Application no: H04-0522-15

Description: Construction of a single storey extension comprising a bedroom and ensuite shower

Location: 7 GOXHILL AVENUE
DONINGTON
SPALDING
PE11 4SZ

Amendment: Storm drainage to soakaway indicated (dwg. no.
15020:02A and 15020:05B)

Project: Alterations & Extensions to 7 Goxhill Avenue
Client: Mrs. Crossland
Drawing Title: PROPOSED SITE PLAN
Project No: 15020
Scale: 1:200 @ A4
Drawing No: RL
Rev: 1

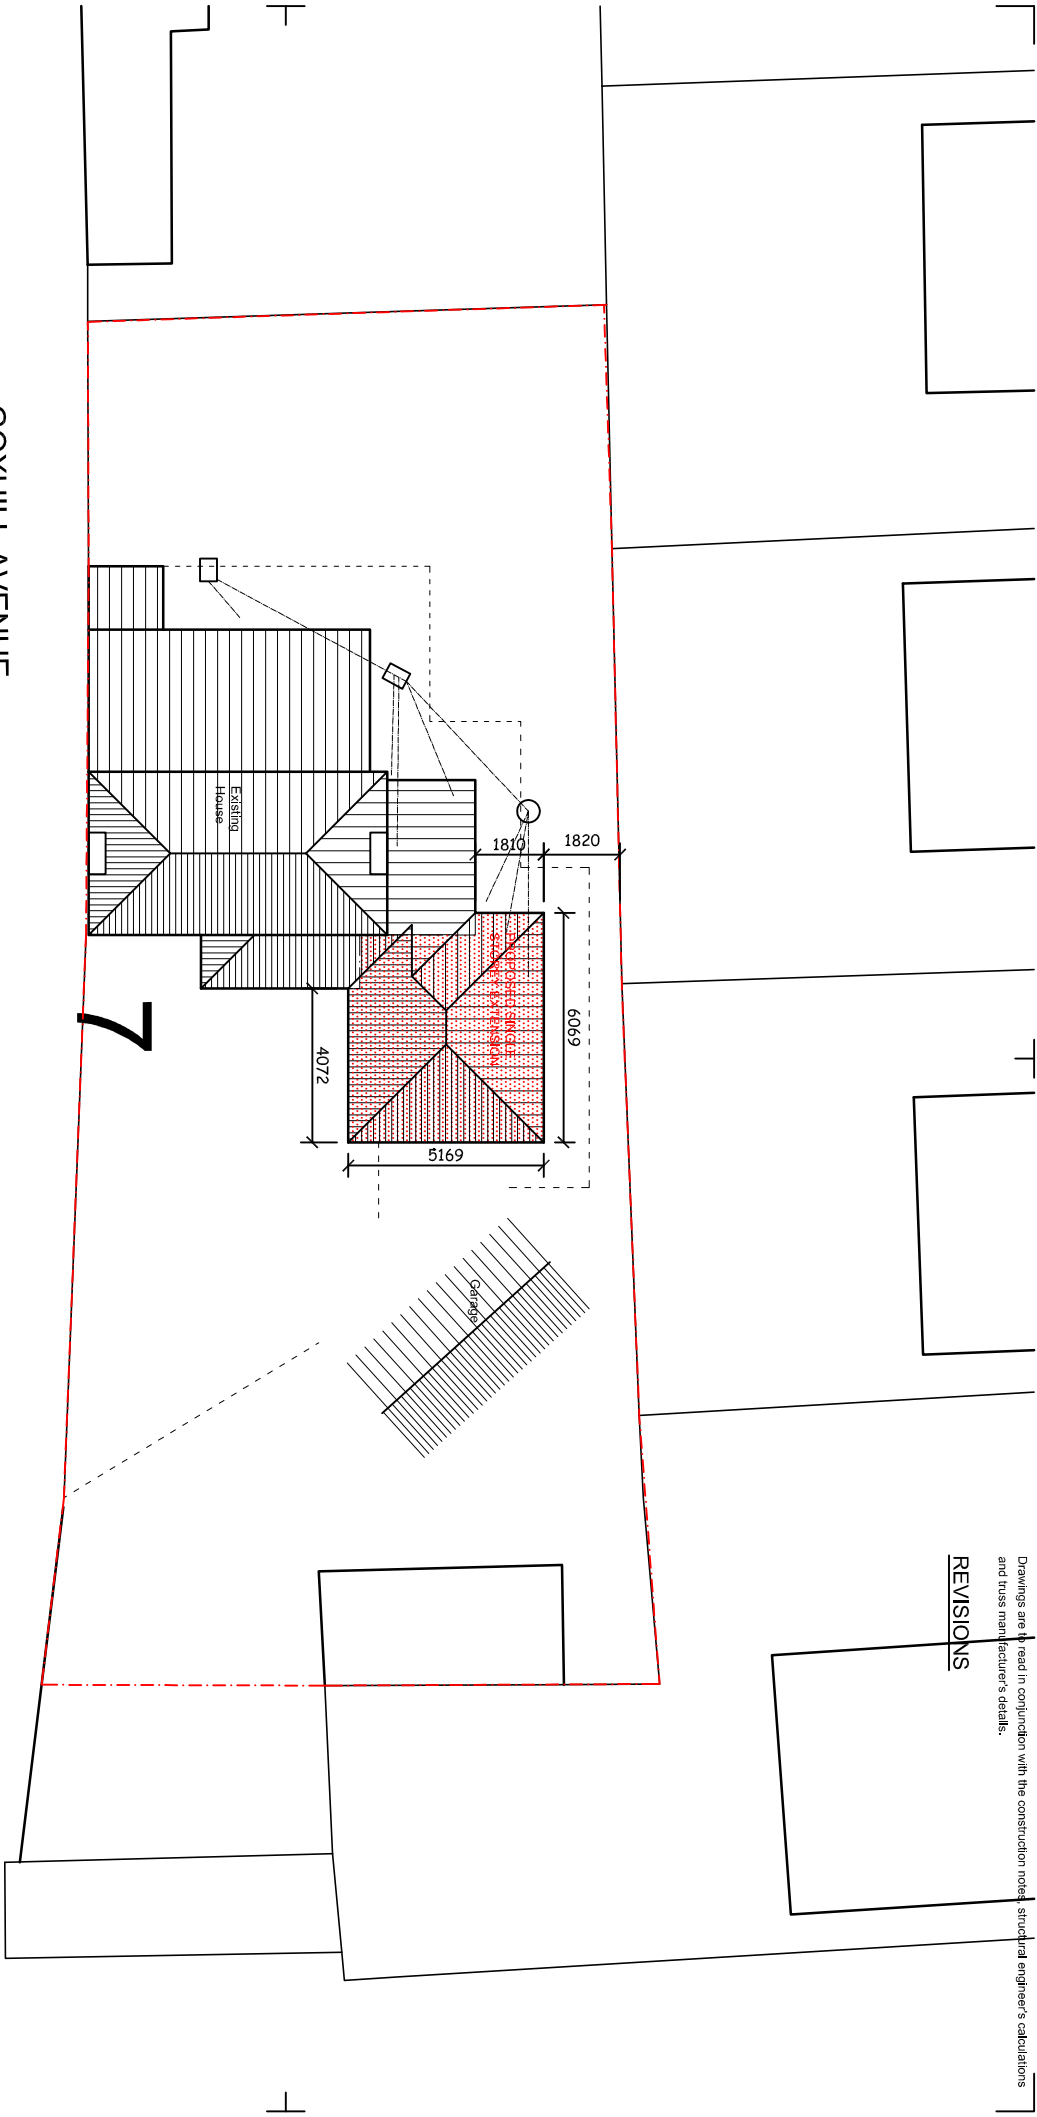
It is intended to carry drains from the two new RWP's to a new soakaway in the front garden.

Drawing Title:
PROPOSED
GROUND FLOOR PLAN

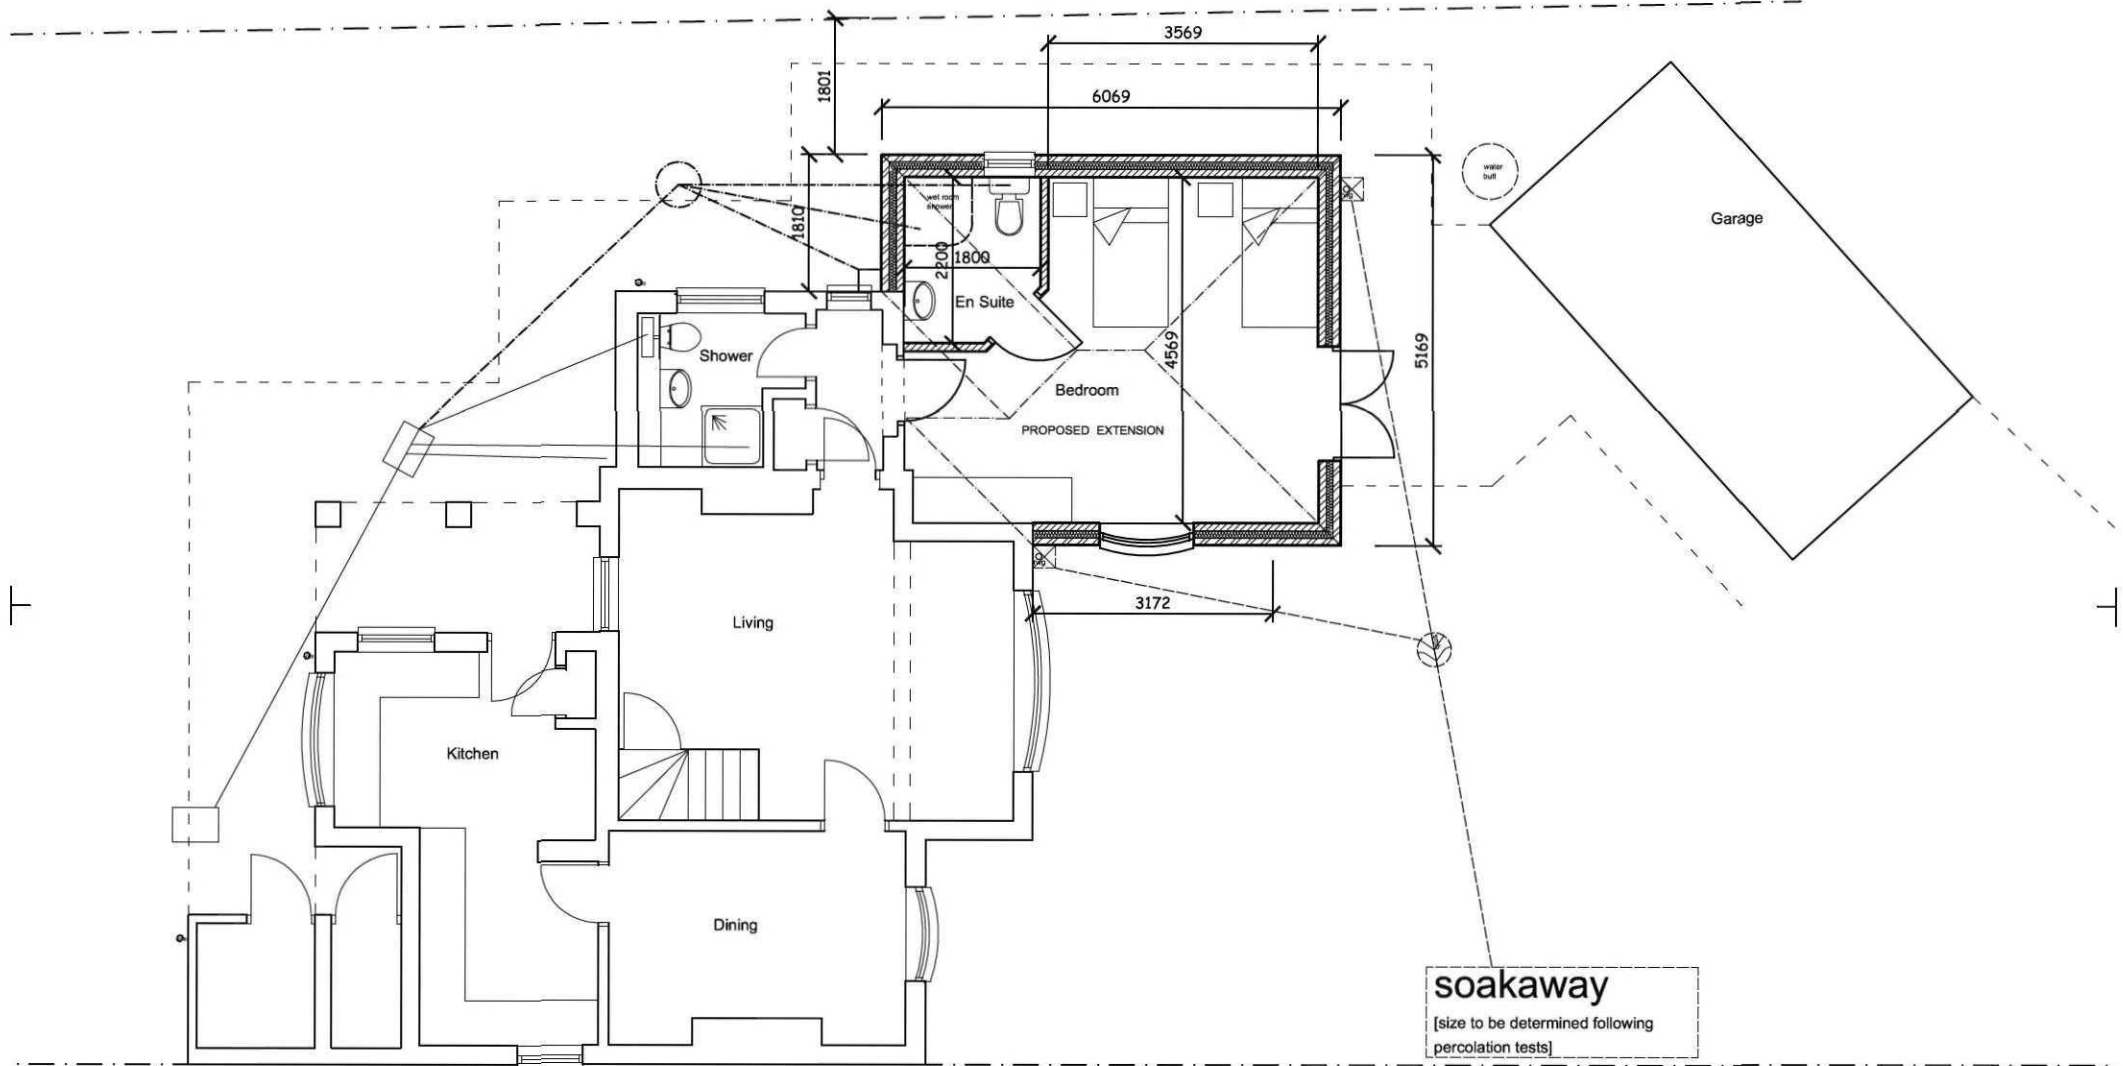
This will located a safe distance from new and existing buildings.
